Engineers Comments Regarding Surface Water Drainage

Application Reference:	M/58/25/PL	Reviewer Reference:	ADC/SB
Planning Officer:	Harry Chalk	Date of Review:	27/10/2025
Site Name:	86 Ancton Way Elmer PO22 6JP		
Application Description:	Demolition and erection of 1 No dwelling (resubmission following M/22/25/PL). This application is in CIL Zone 4 and is CIL Liable as a new dwelling.		
Assessment Number:	1 of 1

- **Proposed Surface Water Drainage 006 PL3**
- **Flood Risk Assessment & Management of Surface Water Run-off - February 2025**

PROPOSED SURFACE WATER DRAINAGE

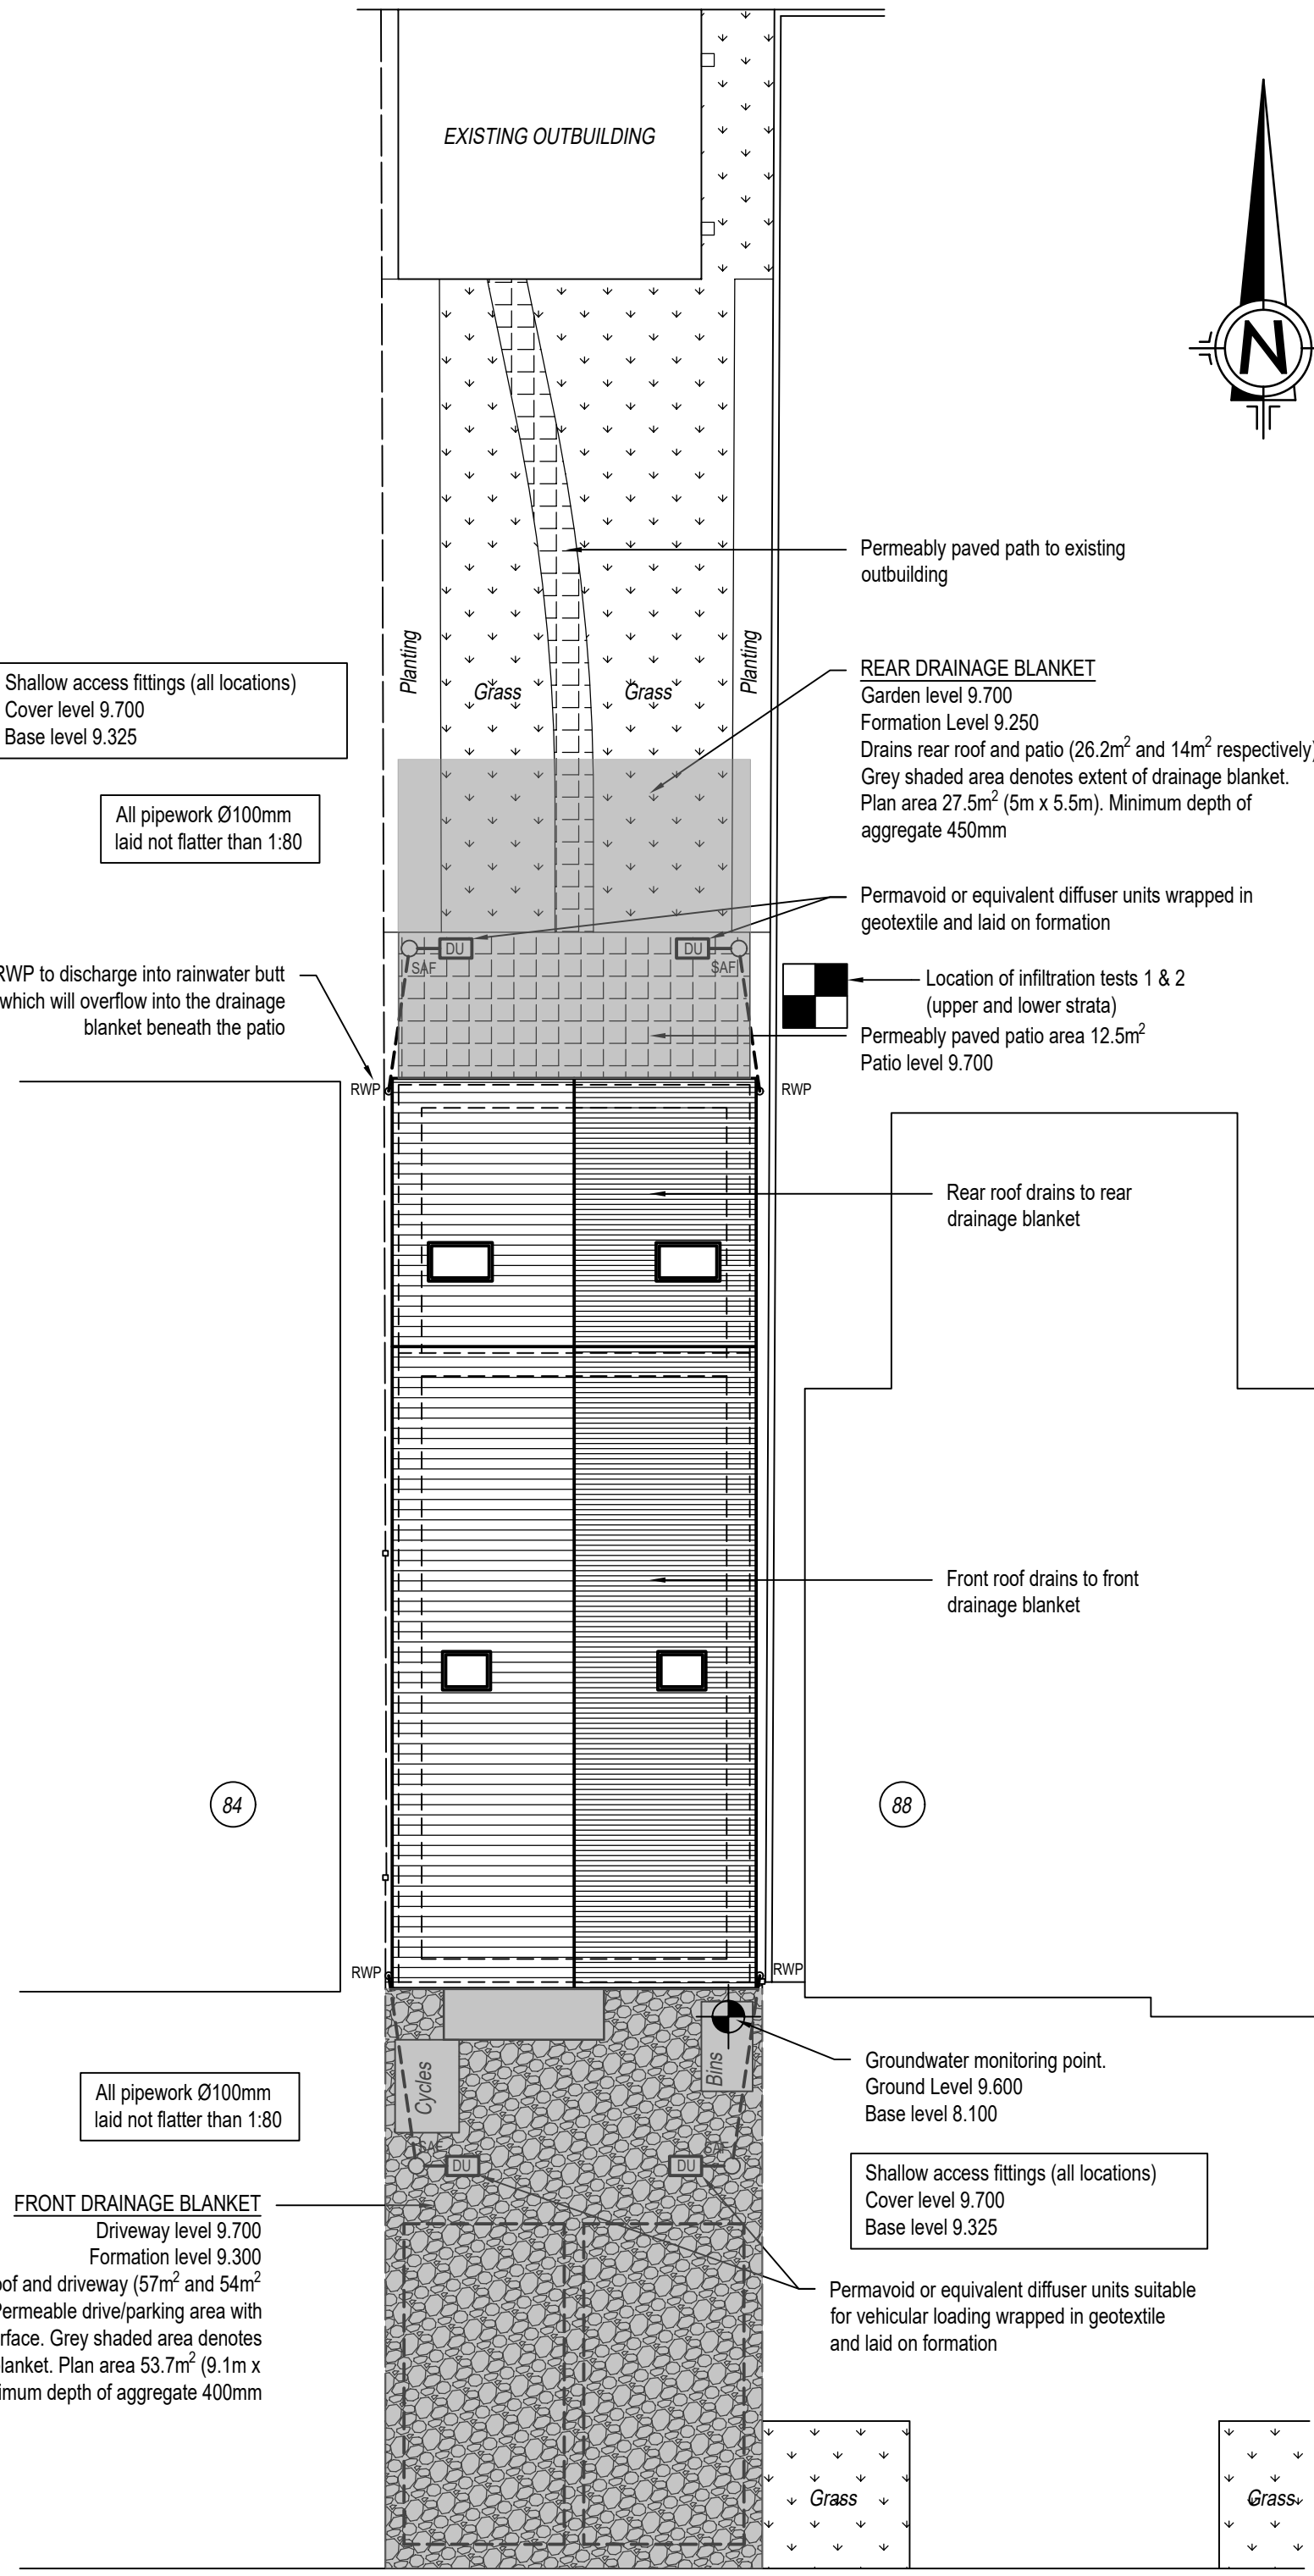
- 1.1. The designer proposes to drain the new dwelling and associated patio and driveway to 2 infiltration blankets at the front and rear of the house. We are supportive of the use of infiltration as the second highest priority disposal option (after water reuse); however, the designer has not adequately

demonstrated that infiltration is viable. Nor have they presented any evidence of an alternative disposal location should that be the case. Therefore, it has not been demonstrated that the site can be sustainably drained, and an **objection** must be lodged.

- 1.3. To comply with the national standards for SuDS and The SuDS Manual the design must allow for 1m of unsaturated ground between the base of the infiltration blankets and the peak groundwater level. This would mean that the base of the blankets would need to be set 9.37mAOD. Both infiltration blankets are set lower than this and would need to be raised to be compliant.

- 1.4. It is assumed that this could be achieved within the confines of the site. However, the applicant has not submitted adequate infiltration testing to demonstrate that infiltration at this depth is viable. Furthermore, the applicant would have to demonstrate that infiltrating at these depths would not be into made ground. No evidence of the geological strata has been submitted.
